PLANNING BOARD REPORT PORTLAND, MAINE

New Yard at Canal Landing
Boatyard and Boat Repair Facility
40 West Commercial Street

Amendment to
Level III Site Plan, Conditional Use, Shoreland Zone, Flood Plain, Site Location of Development
New Yard, LLC, Applicant

Submitted to: Portland Planning Board: Public Hearing Date: October 22 2013 Project # 2013-224 Amending # 2012-575 & # 2013-201 CBL: 59-A-1,2,3,4,5,6,7,8,9,10,11,12	Prepared by: Bill Needelman, Senior Planner Date: August 17,2013 Planning Board Report Number: #45-13
--	---

PROJECT: CANAL LANDING  
 SHEET TITLE: SITE DEVELOPMENT PLAN PHASE 1A (SUMMER/FALL 2013) AND 1B (DATE UNDETERMINED)  
 CLIENT: NEW YARD LLC  
 58 FORE STREET  
 PORTLAND, ME 04101

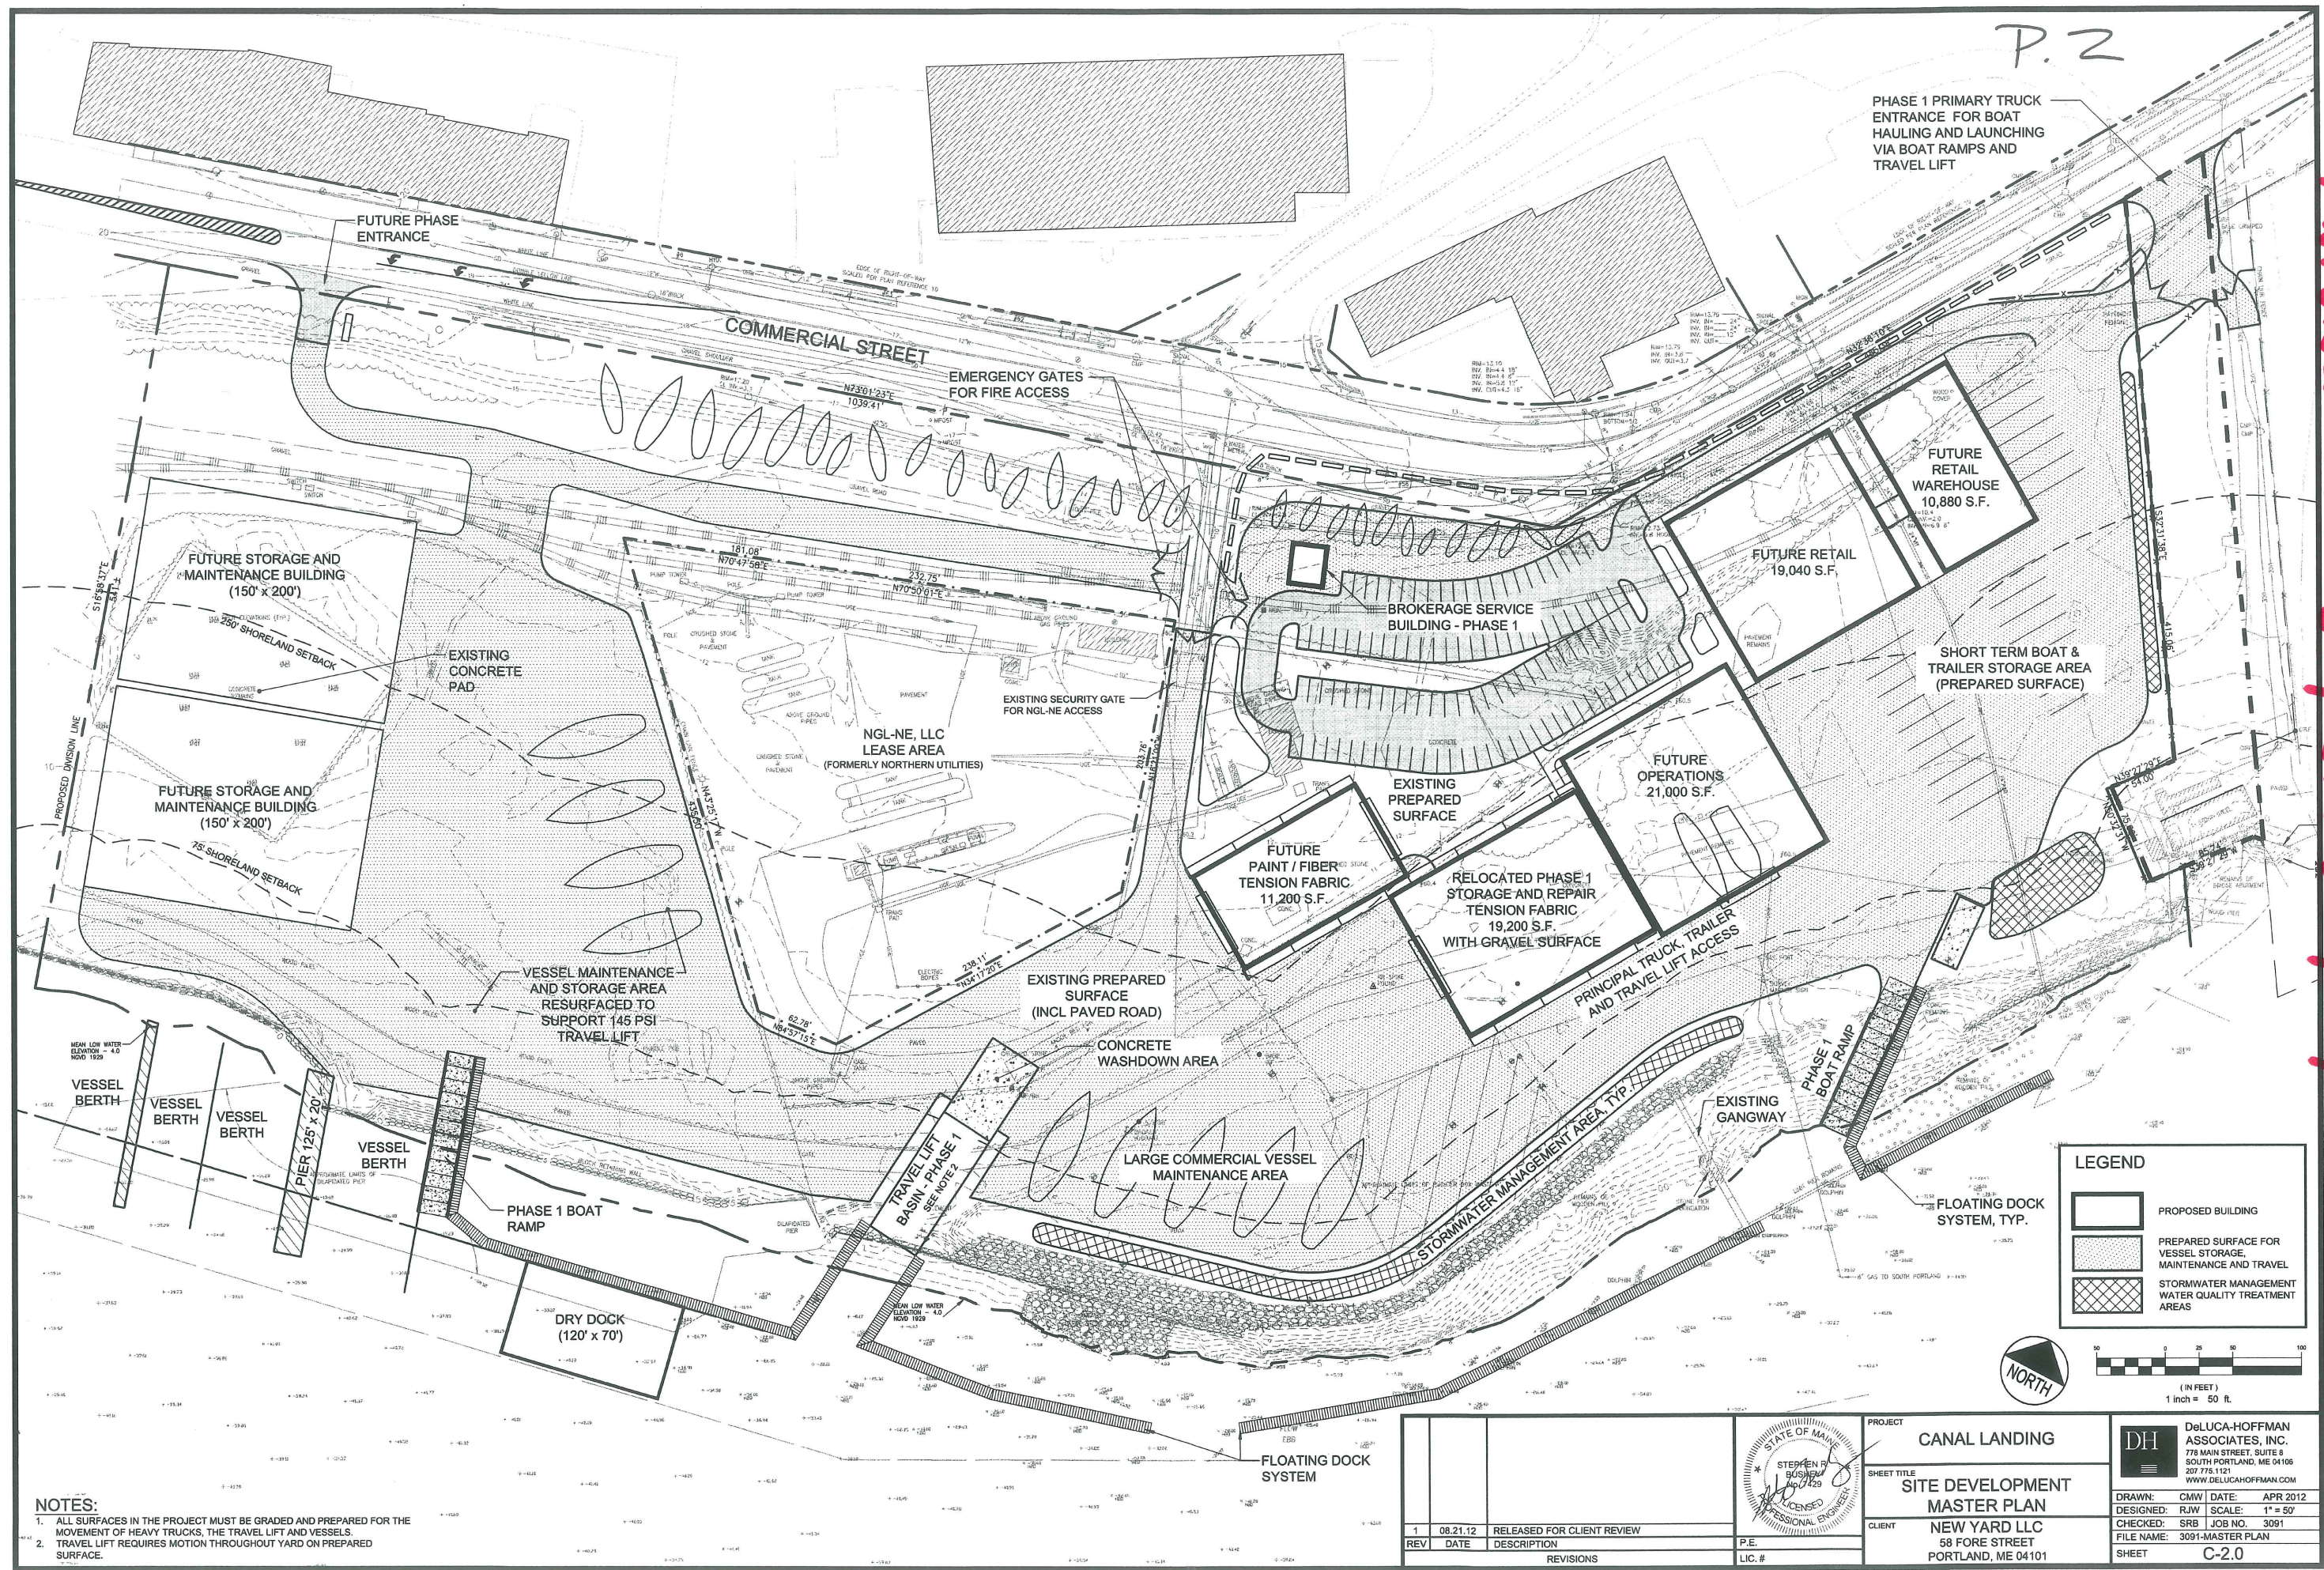
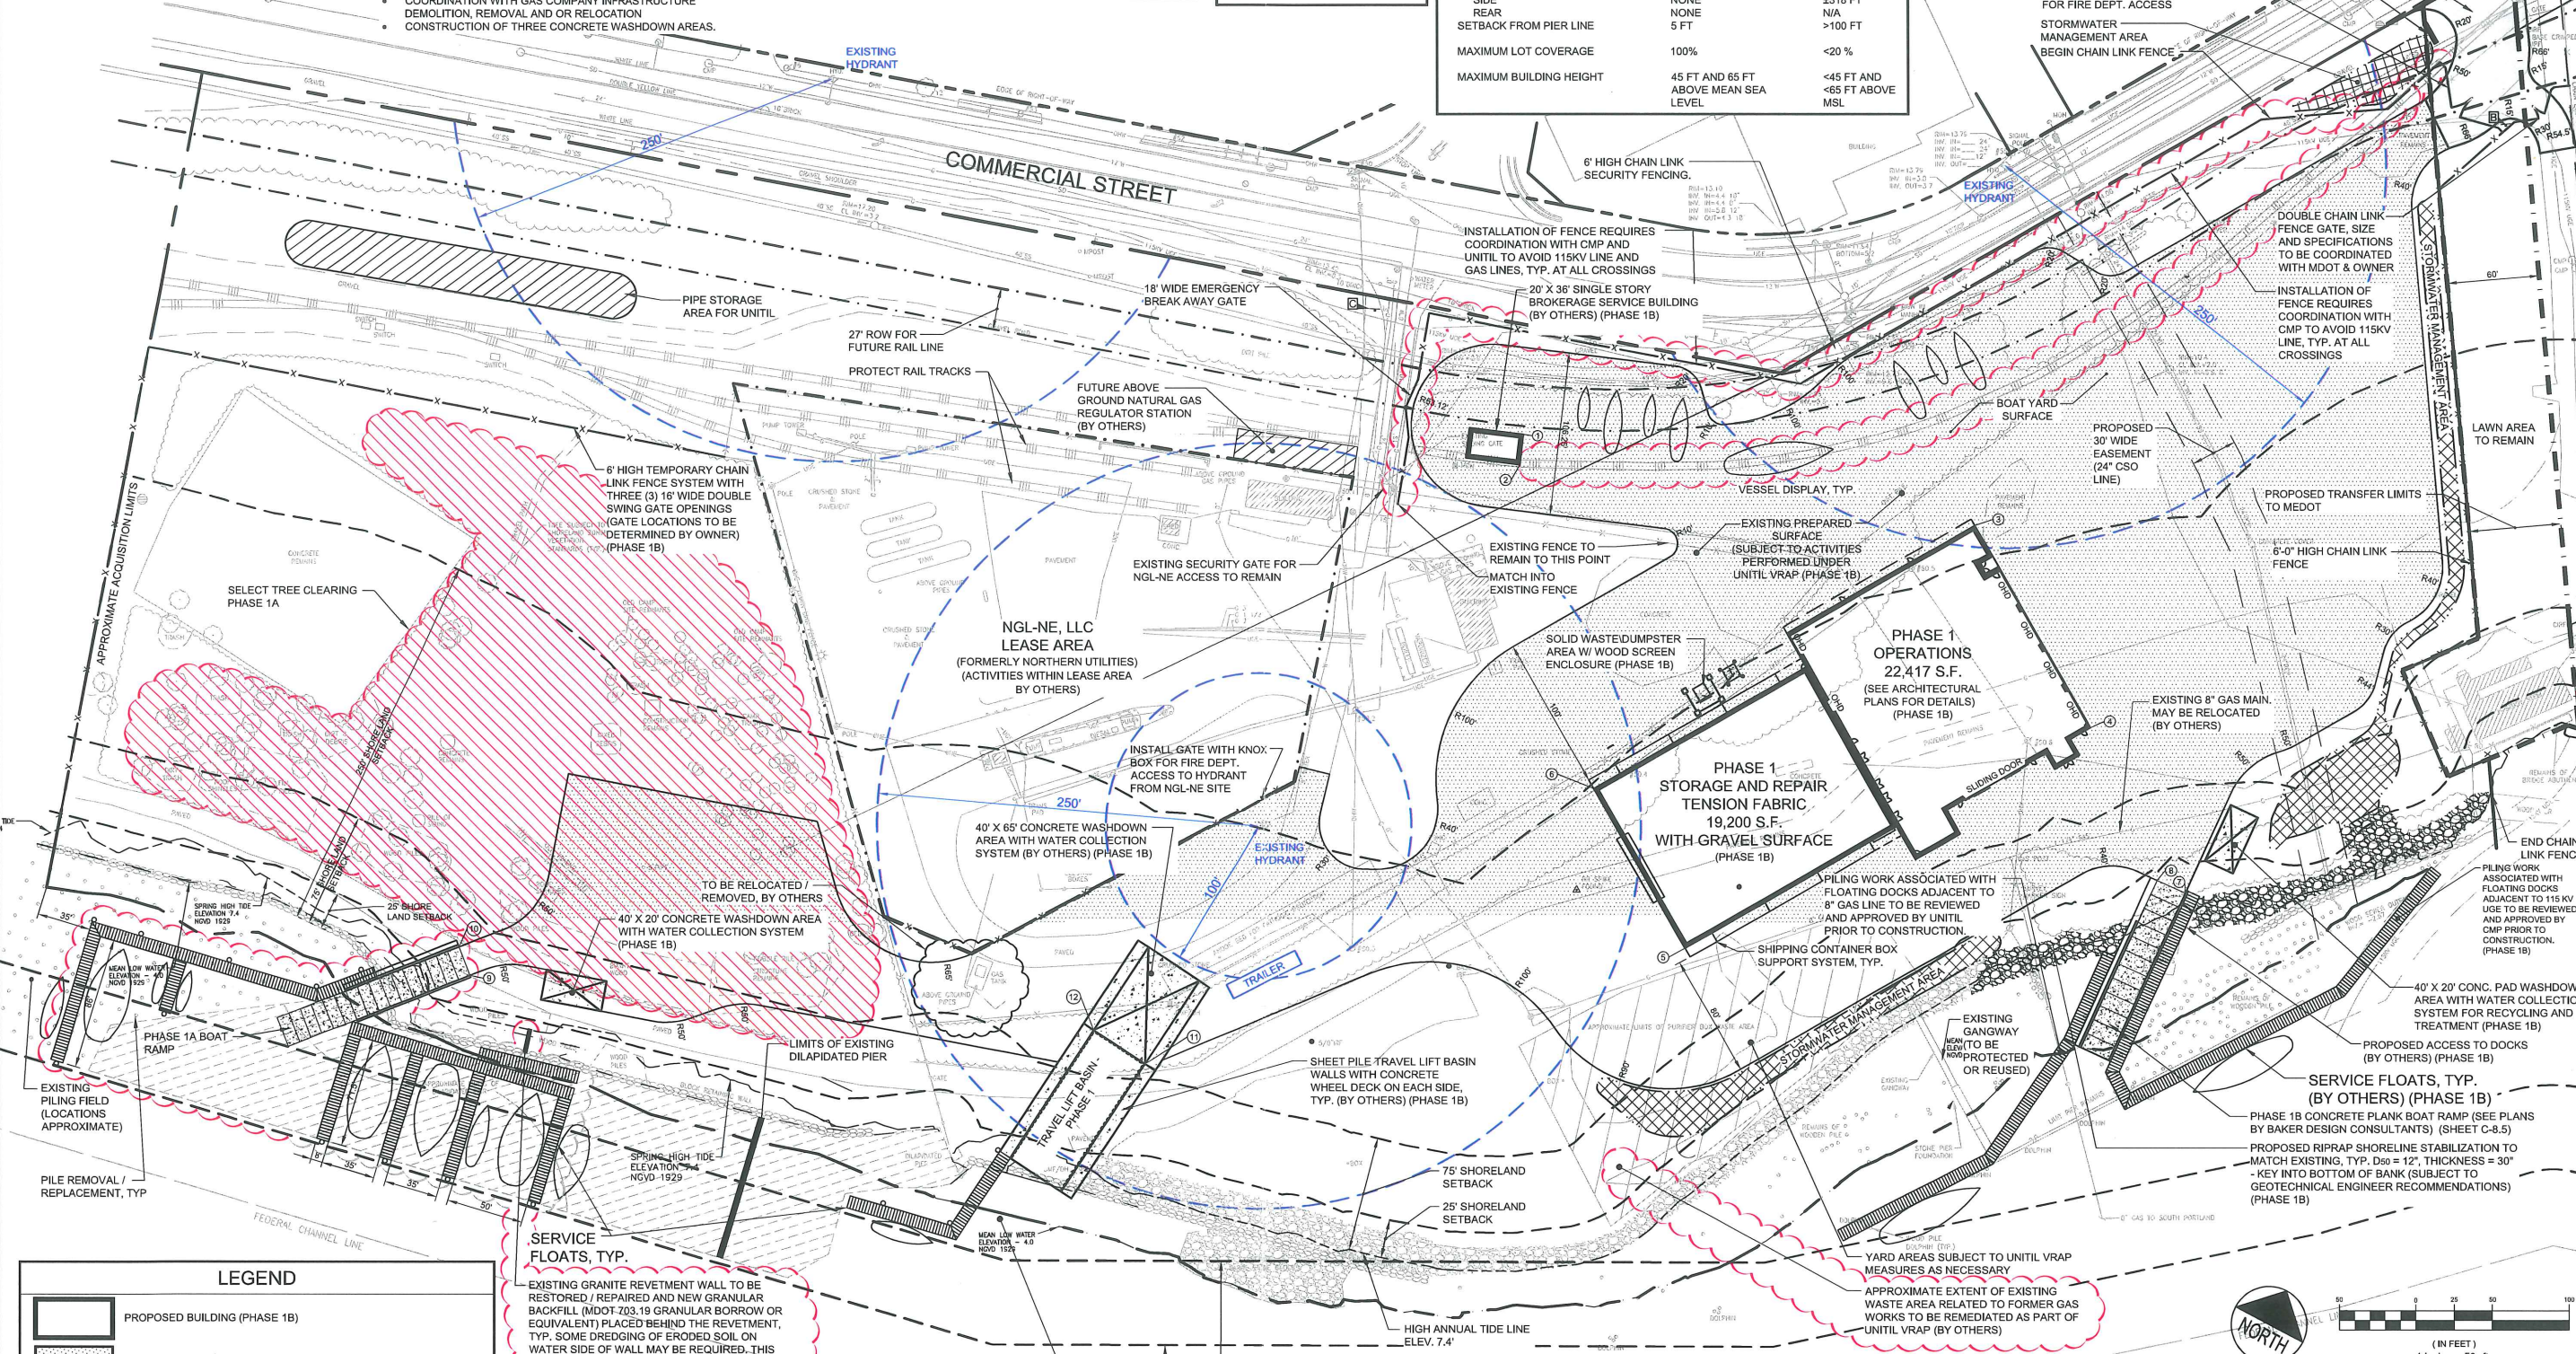
Requested Amendments: The amended plan moves the two primary buildings (retaining their approximate size,) eliminates 1 boat ramp and the travel lift basin, and significantly reduces the extent of berthing floats. The amended site plan is referred to as Phase 1B (sheet C-2.1) in the applicant’s material and labeled Attachment P8.

The proposed improvements included with the requested amendment are shown on Attachment P8 (Sheet C-2.1).

DESIGNED BY: CMW  
 CHECKED BY: SRB  
 FILE NAME: 3091.02-GRADING  
 SHEET: C-3.1

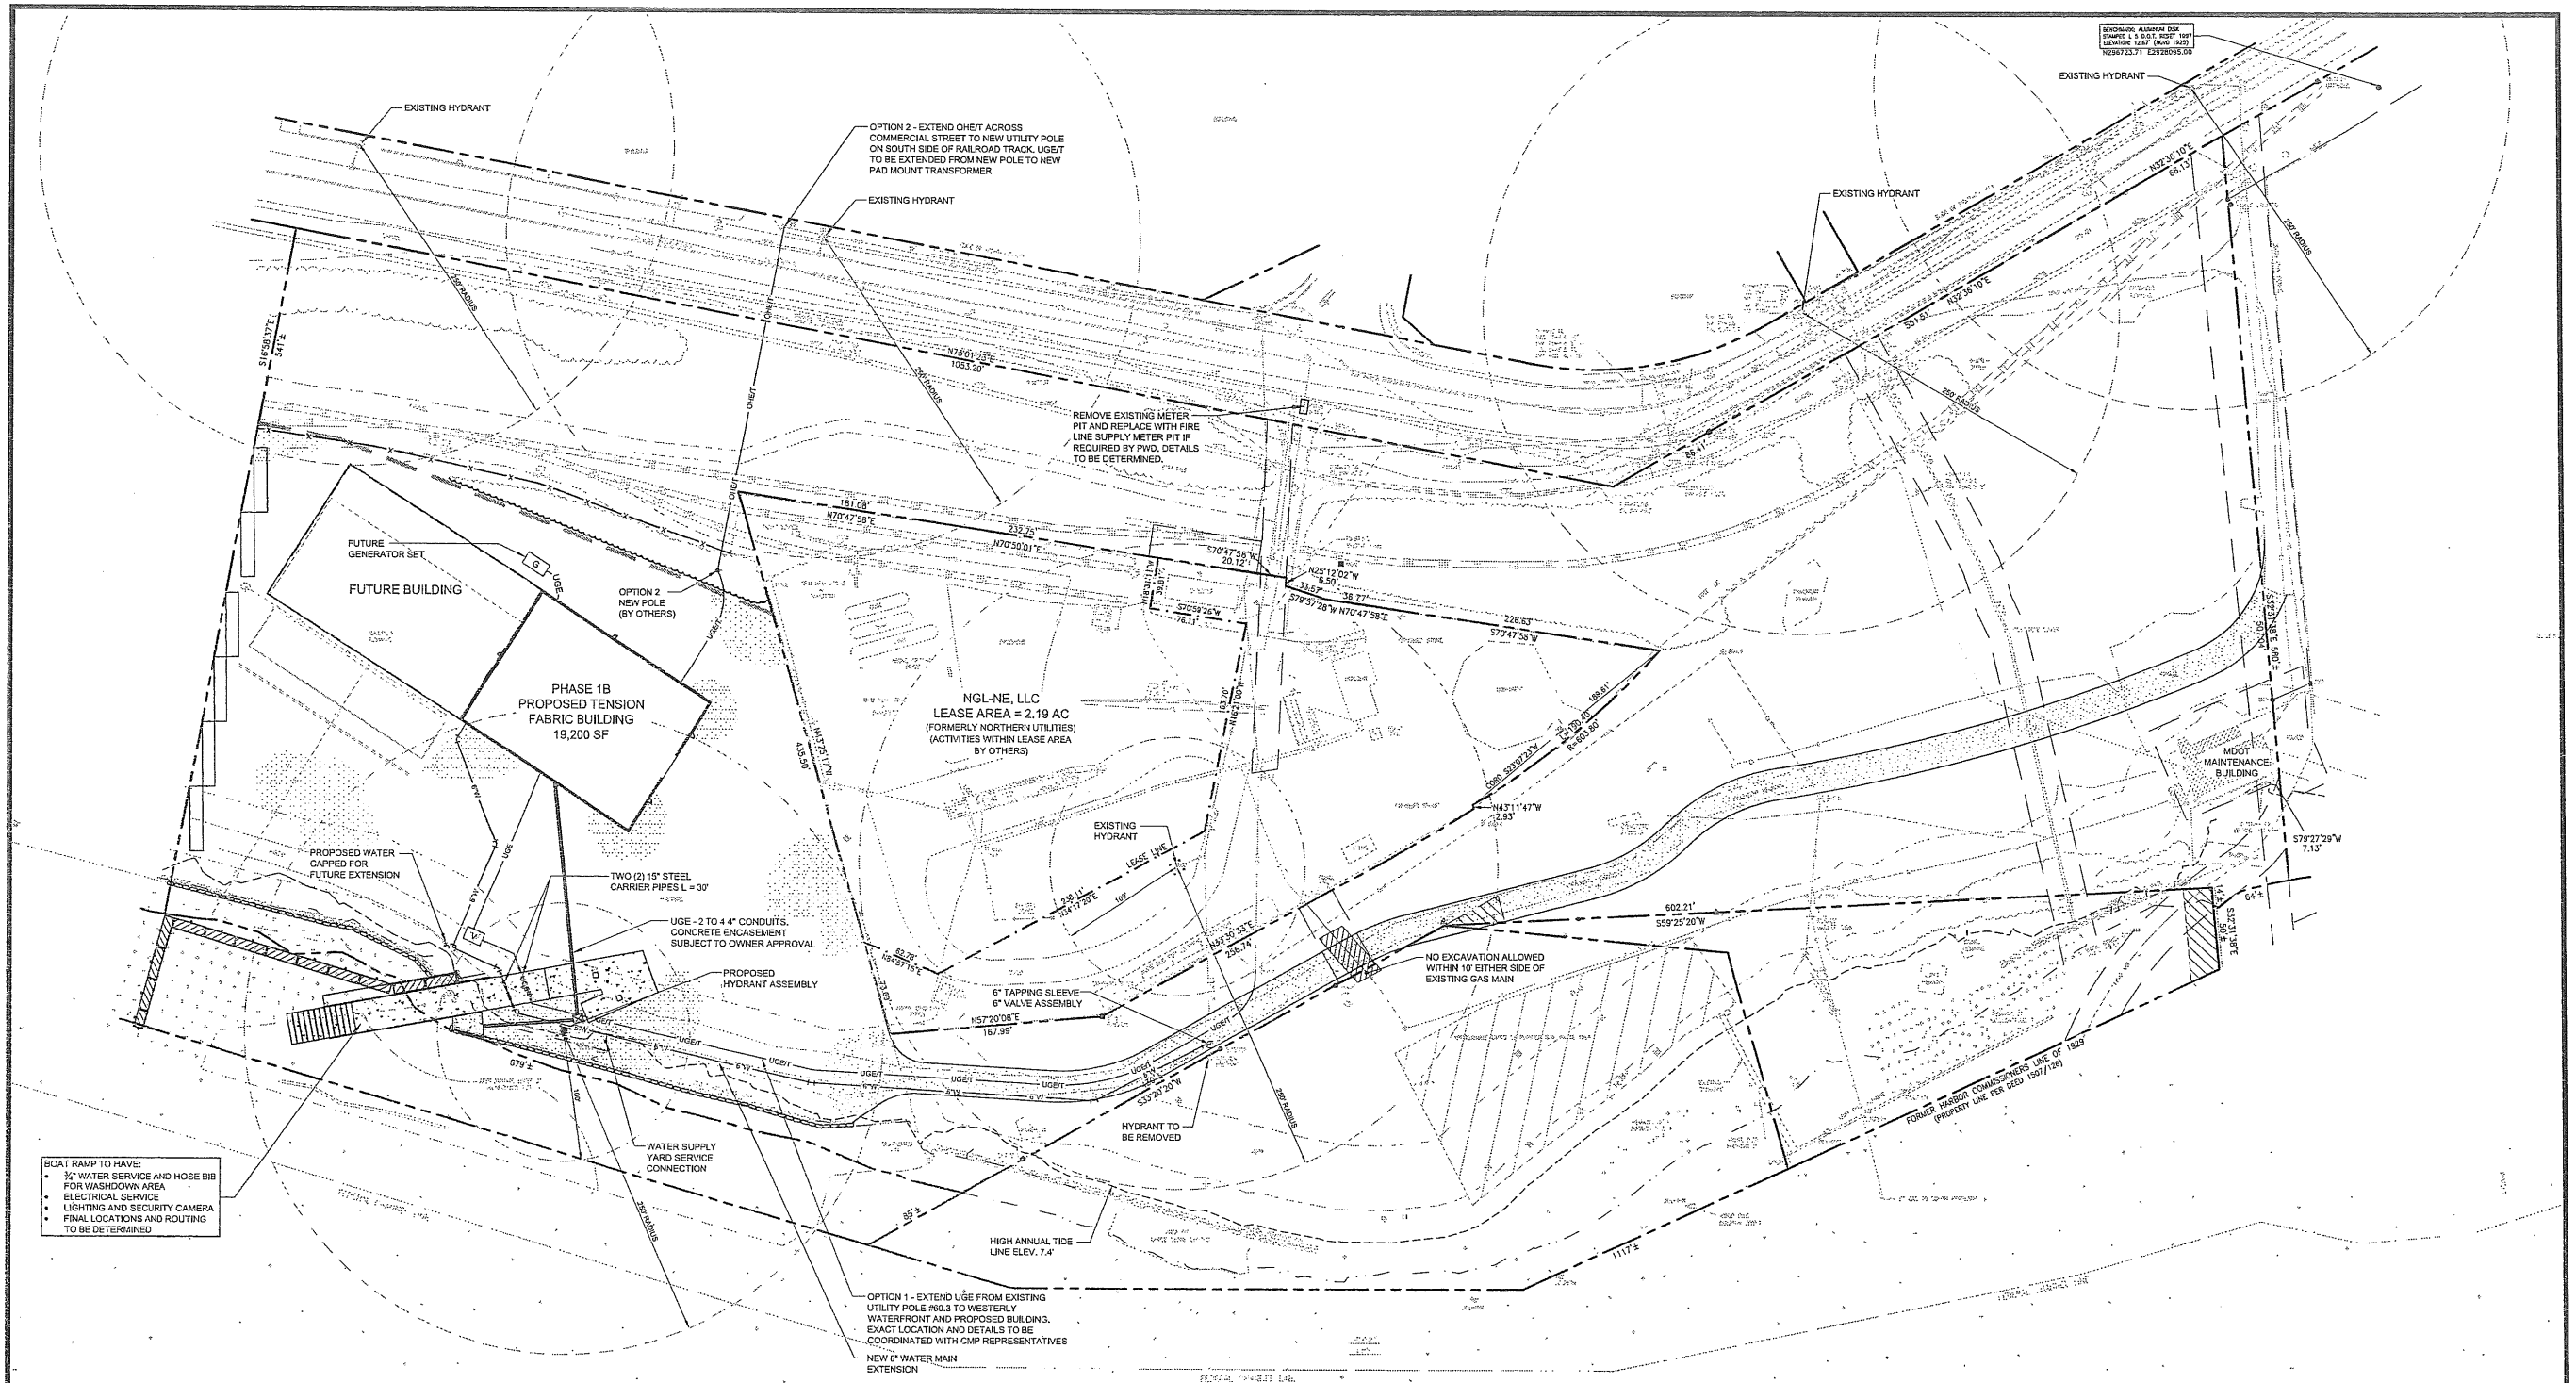
- 1) Per FST's response to comments letter dated 10/15/2013, the Applicant is proposing a manmade pervious surface ("Boatyard Surface") for much of the improved area of the site to meet the General Standards. The amended plans do not indicate the type of surface proposed for the improved traveled-way, and no details were provided with the amended application to depict the construction requirements for this surface. Also, the entry driveway is noted to be gravel, which is not considered a pervious treated surface, please clarify.
- 2) The original application noted that the project was subject to the requirements of the Maine Construction General Permit. The Applicant should verify that they have submitted a Notice of Intent to Comply with the Maine Construction General Permit to the Maine DEP.

Mr. Senus recommends a condition of approval directing compliance with the above comments and further that the previously submitted Stormwater Inspection and Maintenance Manual still applies to the amended site.
